Item No. **Report of the Interim Director of Planning, Regeneration & Public Realm**

Address 261 LONG LANE HILLINGDON

Development: Erection of a part single storey, part double storey side extension and double storey rear extension with loft conversion and roof lights

LBH Ref Nos: **12883/APP/2022/3362**

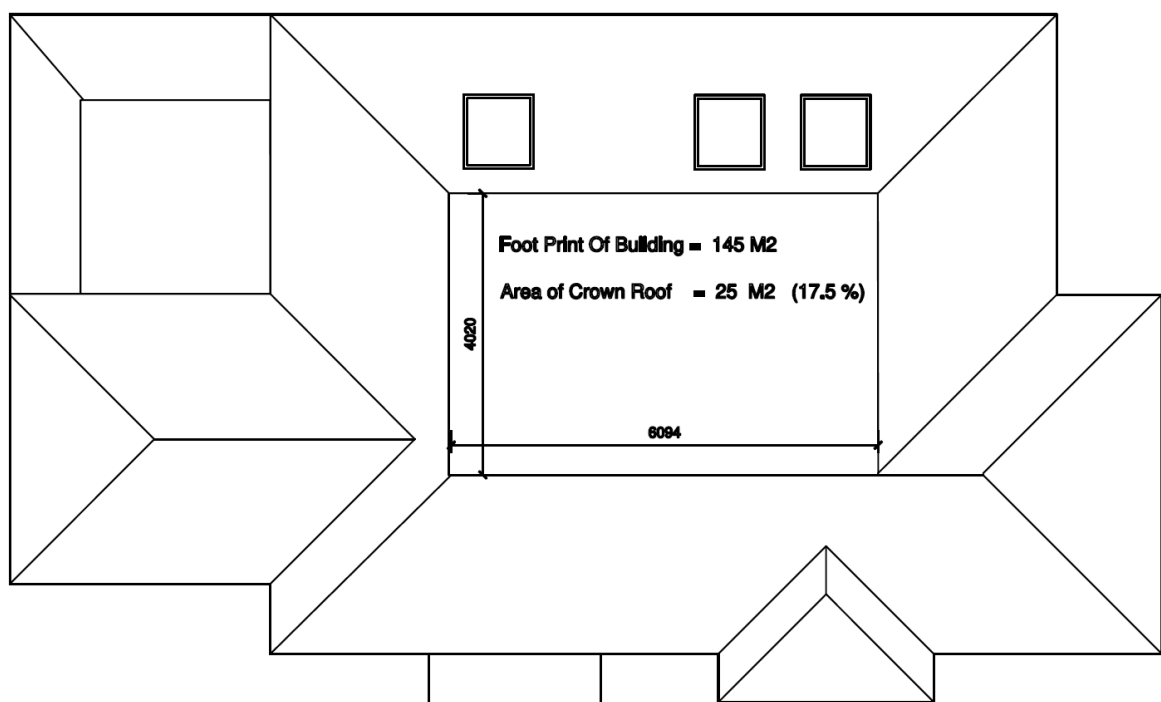
The proposal is considered out of keeping with the prevailing homogeneously designed streetscape. Whilst it is recognised that the scale of the extensions is similar to those which were recently approved, the rear extension introduces a large, uncharacteristic crown roof. The proposed rear extension would significantly increase the bulk of the building, exacerbated by the creation of the crown roof form. As per policy DMHD 1 (viii) large crown roofs will not be supported. This concern has been raised previously in respect of the refused application reference 12883/APP/2022/260. No other material considerations exists in this case to warrant such a stark departure from the Council's adopted policy in this regard. Concerns are therefore raised that the development would fail to respect the character and appearance of the building, streetscene and wider ASLC.

Overall the proposal, by reason of its siting in this visually prominent location, size, scale, bulk and design, including a large crown roof to the rear, would result in an incongruous development which would fail to harmonise with the architectural composition of the original and adjoining buildings. The development would be detrimental to the character, appearance and visual amenities of the street scene and the wider Hillingdon Court Park Area of Special Local Character. The proposal is therefore contrary to Policies BE1 and HE1 of the Hillingdon Local Plan: Part One - Strategic Policies (November 2012), Policies DMHB 1, DMHB 5, DMHB 11, DMHB 12 and DMHD 1 of the Hillingdon Local Plan Part Two - Development Management Policies (January 2020), Policies HC1, D4 and D8 of the London Plan (2021) and the National Planning Policy Framework (2021).

The proposal, by reason of its siting in this visually prominent location, size, scale, bulk and crown roofed design would result in an incongruous development which would fail to harmonise with the architectural composition of the original and adjoining buildings and would be detrimental to the character, appearance and visual amenities of the host dwelling, the street scene and the wider Hillingdon Court Park Area of Special Local Character. The proposal is therefore contrary to Policies BE1 and HE1 of the Hillingdon Local Plan: Part One - Strategic Policies (November 2012), Policies DMHB 1, DMHB 5, DMHB 11, DMHB 12 and DMHD 1 of the Hillingdon Local Plan Part Two - Development Management Policies (January 2020), Policies HC1, D4 and D8 of the London Plan (2021) and the National Planning Policy Framework (2021).
